Rezoning Transportation Analysis

Petition Number: 2023-047

From: Jake Carpenter, PE
Jacob.carpenter@charlottenc.gov
980-221-5675

Date	Description
8-24-23	First Review (IW)
11-21-23	Second Review (IW)
01-24-24	Third Review (KC)

SHEET TITLE:
SCHEMATIC SITE PLAN

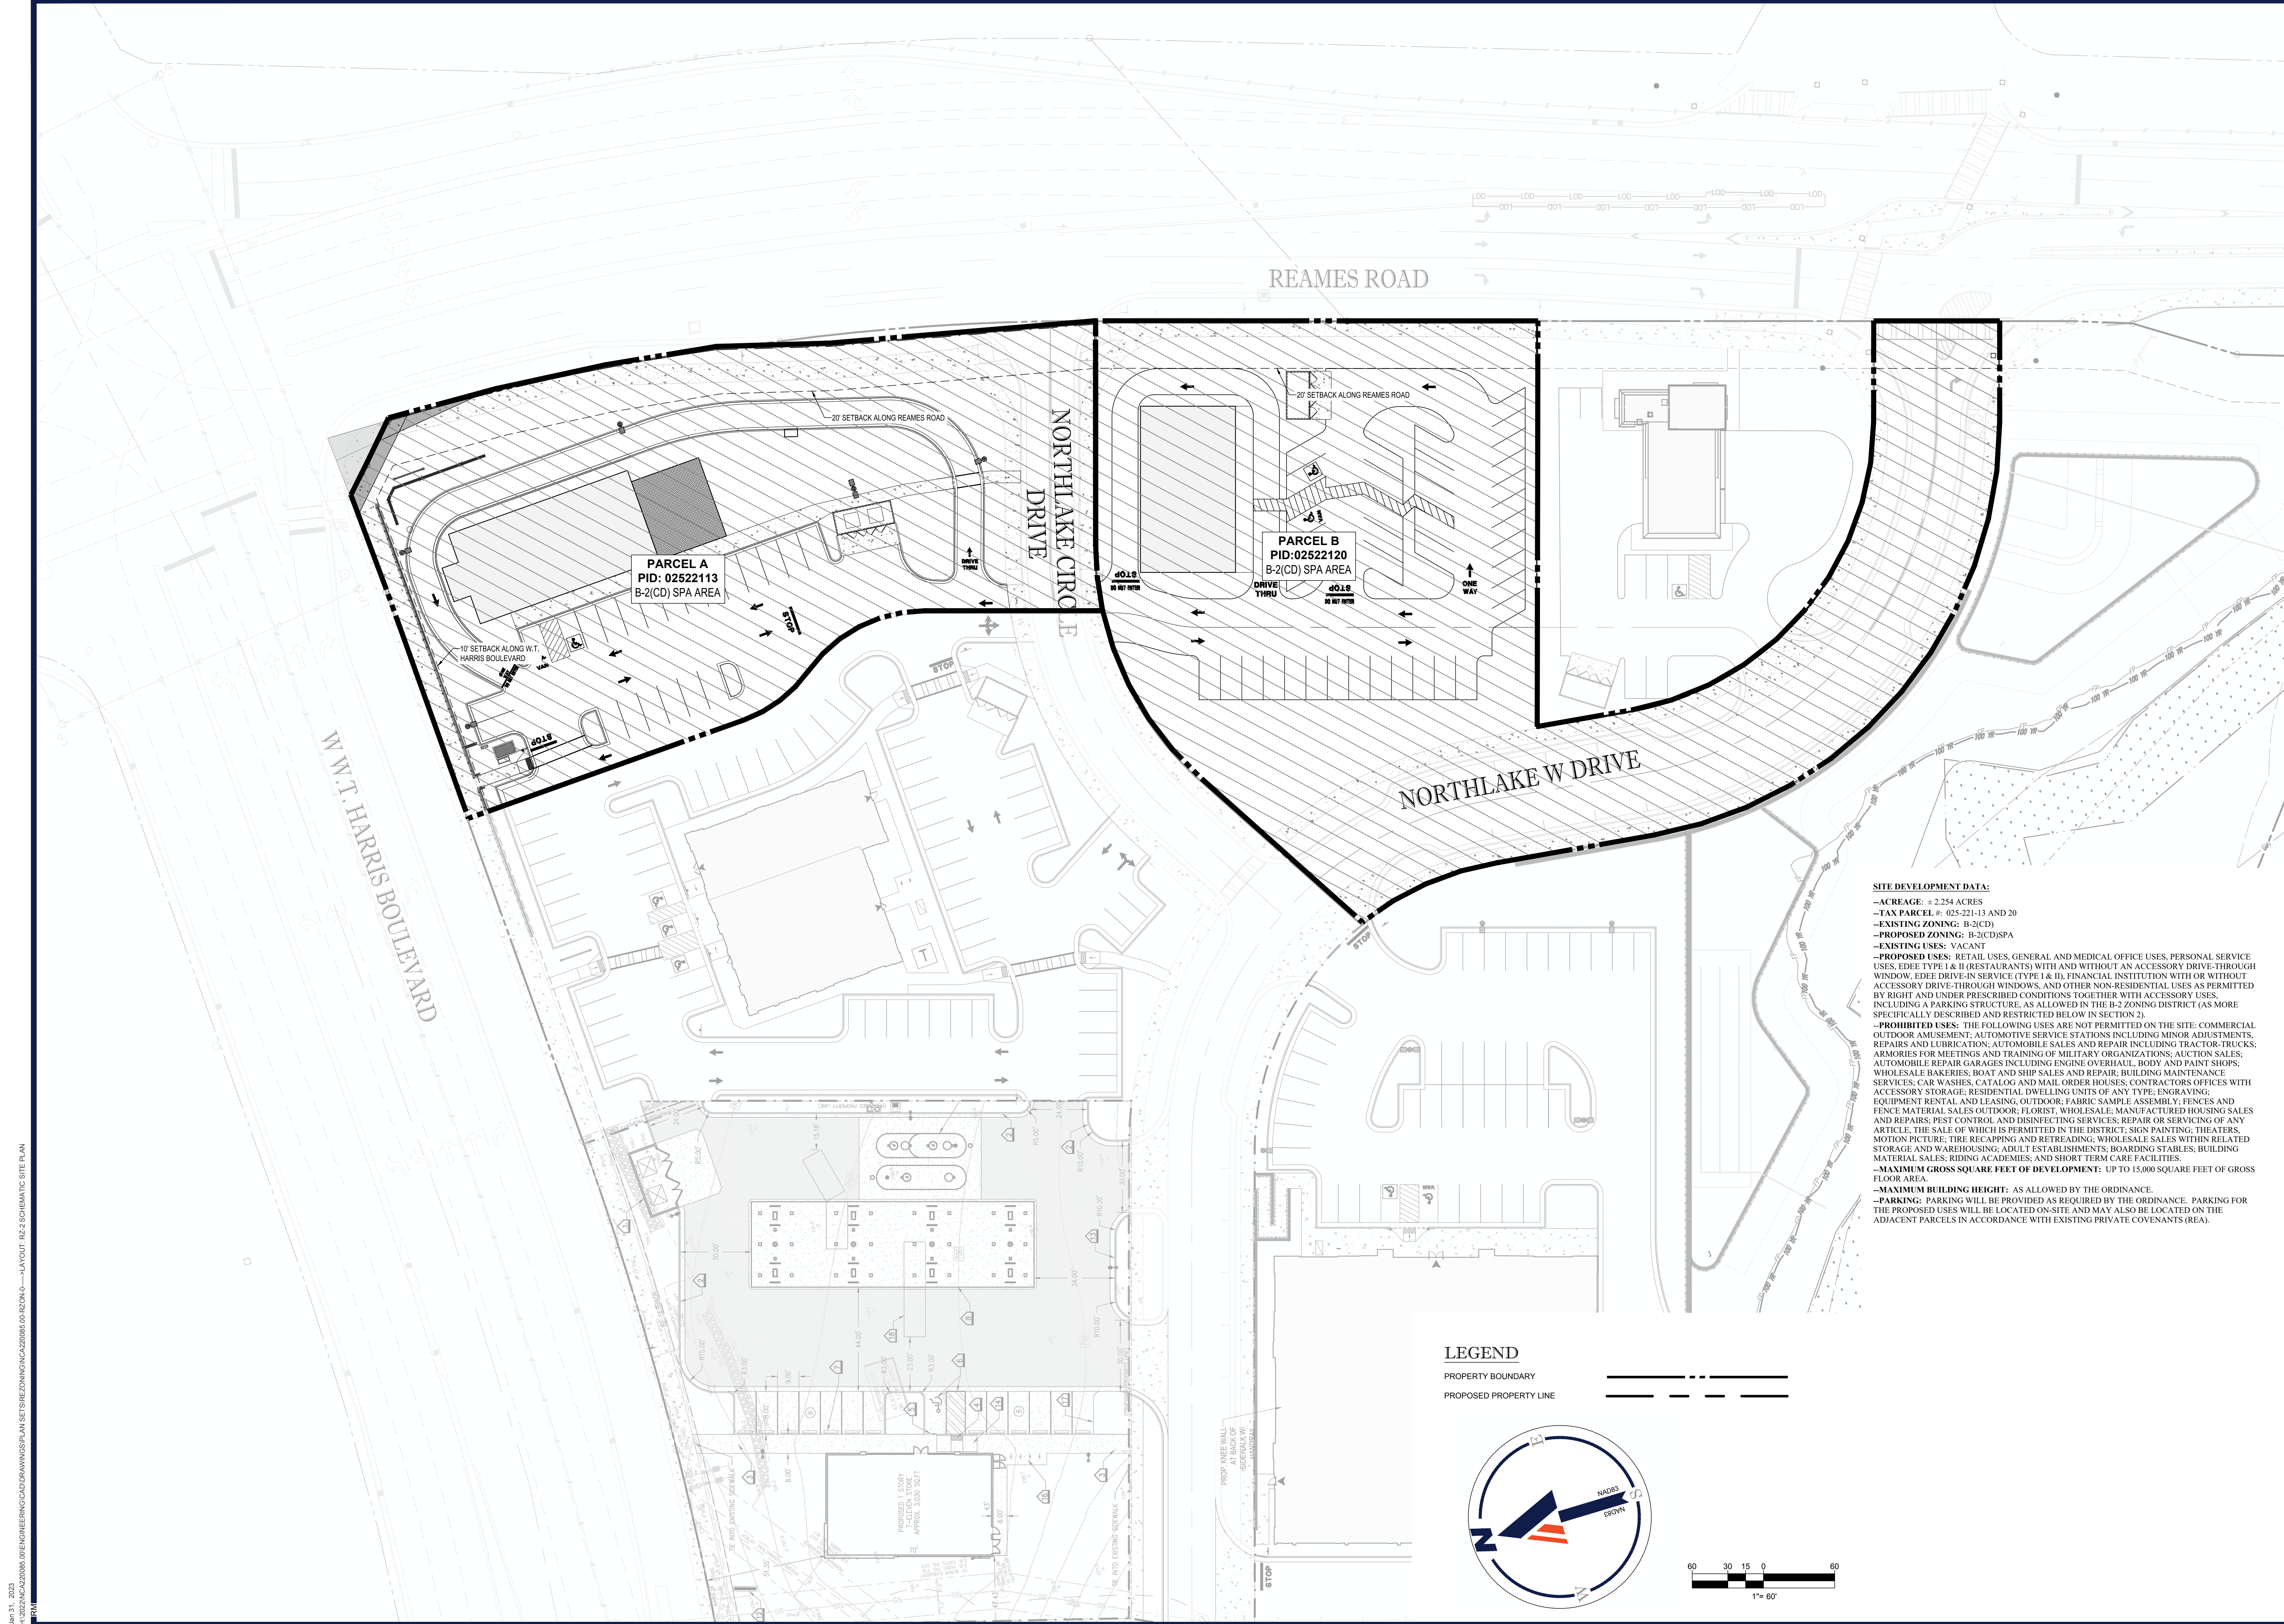
- a. ~~W T Harris Blvd:~~ Location of future back of curb and gutter to be 44 feet from roadway centerline to accommodate the Charlotte Streets Map with a roadway typical section of 6+ Boulevard, Shared Use Path.
- b. ~~Reames Road:~~ Location of future back of curb and gutter to be moved to 38 feet from roadway centerline to accommodate the Charlotte Streets Map with a roadway typical section of 4+ Avenue, Buffered/Separated Bike Lanes.

~~Label and dimension the curb and gutter from the centerline for each road on the site plan.~~

~~**Clarifying Comment:** Site plan needs to Label and dimension the curb and gutter from the centerline for each road on the site plan.~~
